Consultation Response from KC, Highways Development Management
2020/90367 adj, 111, Marsh Lane, Shepley, Huddersfield, HD8 8AS
Outline application for erection of detached dwelling
Date Responded: 12/03/20 Responding Officer: J Turner Responding Ref: K12-32/2

This application seeks outline approval for the erection of a detached dwelling at land adjacent to 111 Marsh Lane, Shepley.

title outline sketch plan proposal
number 19084D-02-P04
scale 1:200
size A1

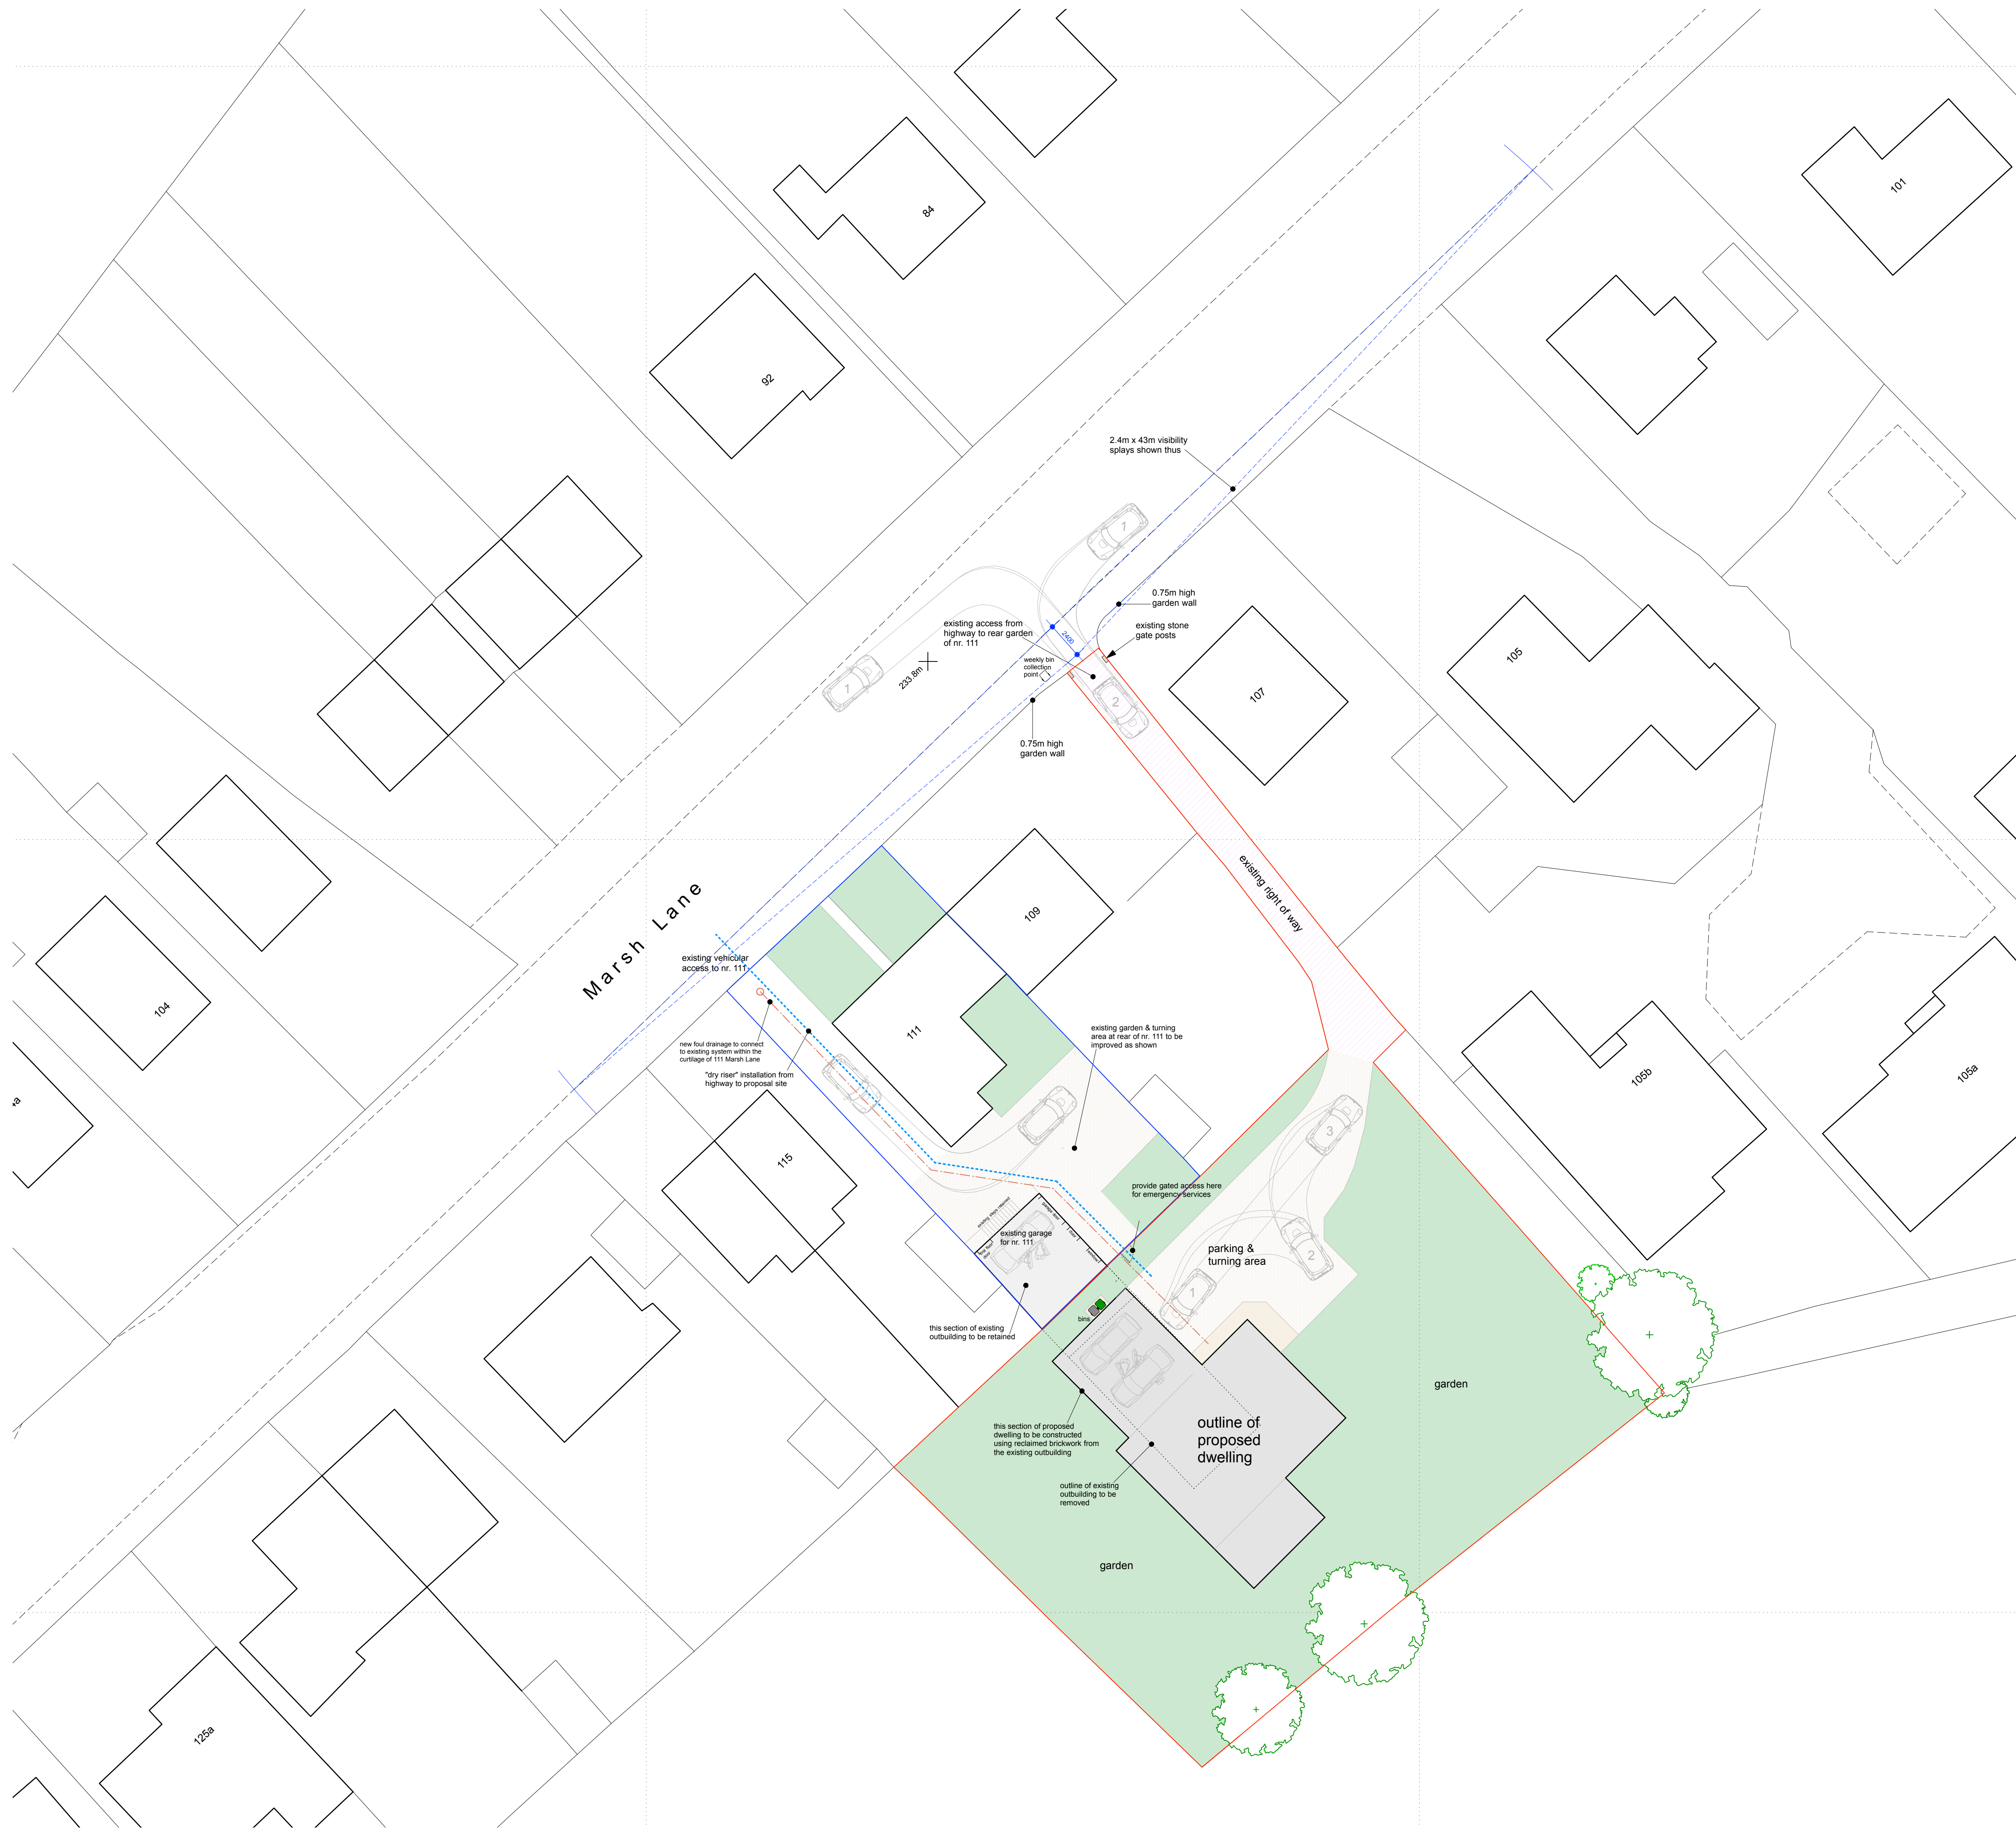
The applicant received pre-application advice on matters such as bin collection, access widths, and access by emergency services. This advice has been followed in the drawing submitted, with a bin collection point demonstrated adjacent to the public highway, and a dry riser arrangement being installed to allow adequate facilities for the fire service.

A double garage is shown with parking and turning to the front of this also shown on drawing no. 19084D-02-P03. A reserved matters application should demonstrate off-street parking in line with the recommendations in Kirklees' Highway Design Guide SPD. Any gates should be set back 6.0m from the carriageway of Marsh Lane.

Visibility splays of 2.4m x 43m have been dimension on the submitted drawing. This is commensurate with the 30mph speed limit on Marsh Lane.

Whilst not being considered at this stage, there should be a clear route from the bin storage point to the collection pad. Presently, the bins would have to be carried over grass from a small section to the side of the proposed garage.

Although a number of elements will require further clarification at the reserved matters stage, including internal turning for a large family car, internal garage dimensions, and bin storage and collection, this scheme is acceptable from a highways perspective for the points being considered.

Gates to be set back

Notwithstanding the provisions of the Town and Country Planning (General Permitted Development) Order 1995, (or any order revoking and re-enacting that order) any gates or barriers for or over a vehicular access or egress shall be set back a minimum of 6.0m from the carriageway edge of Marsh Lane and shall be hung as to only open inwards. So long as such gates or barriers are in position they shall be retained to only open inwards.

Method of storage/access for waste

Before development commences, details of suitable storage, bin presentation points and access for collection of wastes from the dwellings hereby approved shall be submitted to and approved in writing by the Local Planning Authority. The approved details shall be provided before first occupation and shall be so retained thereafter.
